**Re: Full application for the erection of 58 dwellings and associated works at land at Dodworth Road, Barnsley, South Yorkshire on behalf of Bellway Homes PLC (LPA application ref. 2010/1098)**

Further to our meeting on the 20<sup>th</sup> October 2010 regarding the above mentioned planning application, I enclose the following revised drawings and plans for your consideration:

Drawing Title  
**Site Layout**

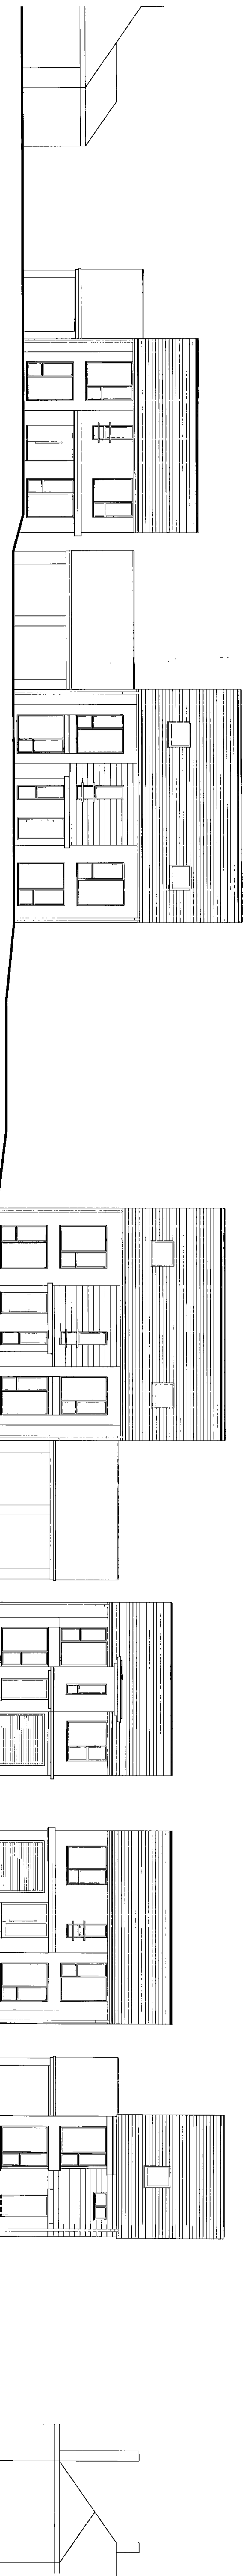
Garden spaces will have 2m close boarded type boundaries. To the frontage of the site and at the site entrance are boundary wall features (see layout plan PL02 Rev B). Matters in relation to boundary detailing shall be confirmed upon the landscape plan, which can be secured by way of condition.

Drawing PL02 Rev B shows that the road width within the site has been increased, with proportional changes to car parking lengths. A turning area at to sewer easement area is provided and the width of the shared surface beyond to the west has been reduced. In addition, the terminating turning heads within the site have been amended to suit cars only.

Drawing PL02 Rev B identifies the proposed affordable housing types and location. You will note the reduction in overall housing numbers proposed but a favorable change in affordable house types (i.e. larger

Drawing PL02 Rev B shows that the garden depths of Plots 28-33 have been increased and the relationship of properties facing Plot 27 has been improved.
